A46 Newark Bypass

Statement of Common Ground with Think Again A46 Winthorpe Action Group

February 2025

Statement Of Common Ground with Think Again A46 Winthorpe Action Group - TA

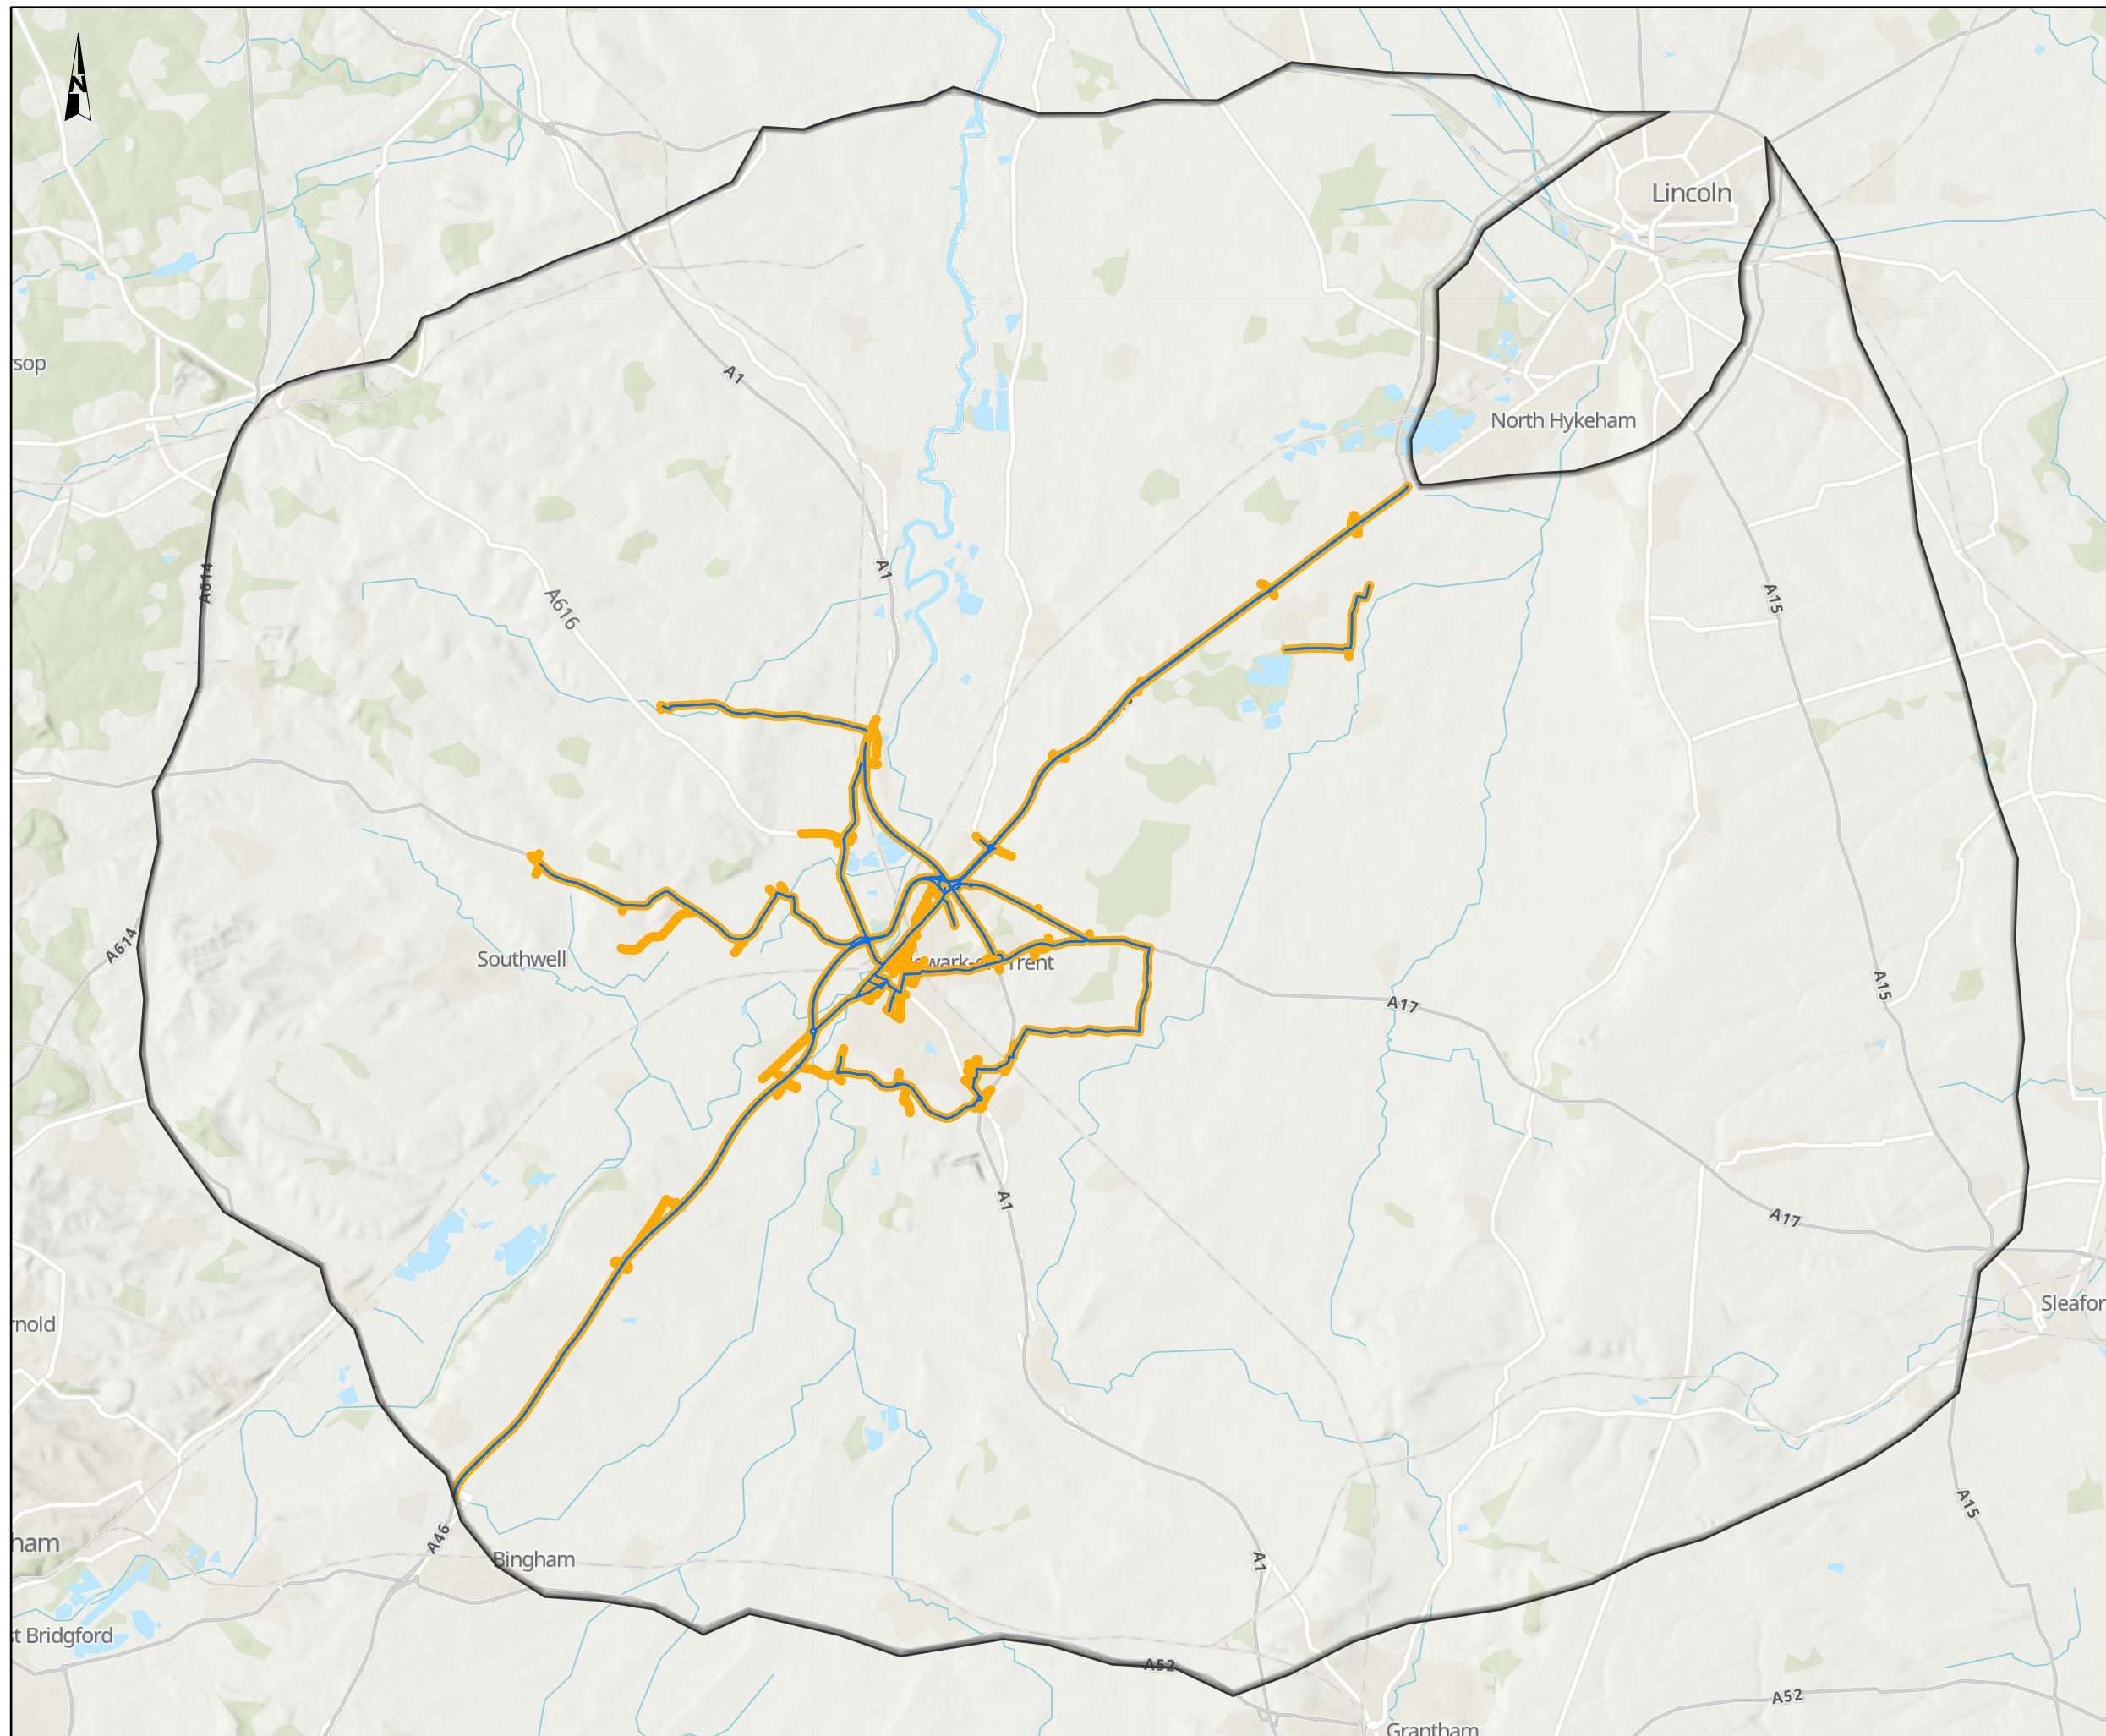
17.	Air Quality	Chapter 5 Air Quality of the Environmental Statement [AS-021] Figure 5.4 Air Quality Affected Road Network of the Environmental Statement Figures [AS-031]	What measures will be put in place to minimise the spread of pollution from road traffic to adjacent properties, some already noted as amongst the 12 most impacted receptors in the analysis area, together with pedestrian routes adjacent to the road	The assessment presented in Chapter 5 Air Quality of the Environmental Statement [AS-021] assesses the impacts of the Scheme on air quality. Dispersion modelling was undertaken as part of the air quality assessment using ADMS-Roads, which is a PC-based model of dispersion in the atmosphere of pollutants released from road traffic sources. The dispersion modelling accounts for all roads within the study area that meet the criteria for assessment. Dispersion modelling to determine the air quality effects includes all roads within 200m of 'affected' roads where they add to total pollution concentrations. Roads modelled within the air quality assessment are	Agreed	12/12/2024

Issue No.	Issue	Document Reference	Think Again Position	The Applicant's Position	Status	Date status confirmed
		Design Manual for Roads and Bridges LA 105 – Air Quality LA 105 – Air Quality		<p>presented in Figure 5.4 Air Quality Affected Road Network of the Environmental Statement Figures [AS-031].</p> <p>Human health receptors have been chosen at sensitive locations within 200m of the air quality affected road network and include residential properties, schools and hospitals (where present), in line with the Design Manual for Roads and Bridges LA 105 – Air Quality. The air quality objectives are not typically assessed at footpath locations as the short-term (1-hour) air quality objectives are unlikely to be exceeded and members of the public are not reasonably expected to spend one hour or longer at any single location along a footpath.</p> <p>Winthorpe village and Langford are located over 200m away from the affected road network and therefore have not been included in the assessment. However, human receptors along the A46 and A1 on the outskirts of Winthorpe, which are within 200m of the affected road network, have been included in the assessment. The predicted concentrations at these receptors, which are below the air quality objectives, are likely to have the highest pollutant concentrations or anticipated to experience highest level of change within the vicinity of Winthorpe village and Langford.</p> <p>During operation of the Scheme there are not predicted to be any exceedances of the NO₂ or particulate (PM₁₀ or PM_{2.5}) air quality objectives (40ug/m³ for NO₂ and PM₁₀, and 20ug/m³ for PM_{2.5}) at any human health receptors within the study area. The maximum modelled concentration for NO₂ in the opening year of the Scheme is predicted to be 31.9ug/m³. The maximum modelled concentration for PM₁₀ in the base year of the Scheme is predicted to be 28.9ug/m³.</p> <p>Figure 5.5 Air Quality Summary of Traffic Data of the Environmental Statement Figures [AS-032] provides detail on why PM_{2.5} has not been considered further within the operational phase of the local air quality assessment.</p> <p>In summary, the Design Manual for Roads and Bridges LA 105 – Air Quality states that there should be no need to model PM_{2.5} as the UK currently meets its legal requirements for the achievement of the PM_{2.5} air quality thresholds and modelling of particulates (PM₁₀) can be used to demonstrate that the Scheme does not impact on the PM_{2.5} air quality threshold. For this assessment, when the maximum modelled road contribution of PM₁₀ of 4.5 µg/m³ from existing traffic in the base year at modelled receptors is combined with the maximum PM_{2.5} background concentration of 9.7 µg/m³ across the study area, the PM_{2.5} threshold of 20 µg/m³ is not exceeded.</p> <p>Considering PM_{2.5} is also a constituent part of PM₁₀, vehicles emission factors, and therefore the existing road contributions, for PM_{2.5} would be even lower than those for PM₁₀. Further to this, the greatest change in annual mean nitrogen dioxide (NO₂) concentrations at modelled receptors in the opening year of the Scheme is predicted to be 3.9 µg/m³ between the Do Something (with the Scheme) and Do Minimum (without the Scheme) scenarios. Changes in PM_{2.5} would therefore be even lower in the opening year of the Scheme, as PM_{2.5} is a constituent part of PM₁₀ and PM₁₀ emissions are an order of magnitude lower than nitrogen oxide (NO_x) emissions which are primarily made up of nitric oxide (NO) and NO₂. As well as this, PM_{2.5} background concentrations are expected to continue falling in the future.</p> <p>Therefore, it can be concluded that the current and future PM_{2.5} concentrations are lower than the current target value of 20 µg/m³ and the Scheme will not</p>

Issue No.	Issue	Document Reference	Think Again Position	The Applicant's Position	Status	Date status confirmed
				<p>impact on the PM_{2.5} air quality threshold at any of the human health receptors considered and no further assessment is required.</p> <p>Therefore, no significant air quality effects are anticipated as a result of the Scheme and no mitigation measures are proposed</p>
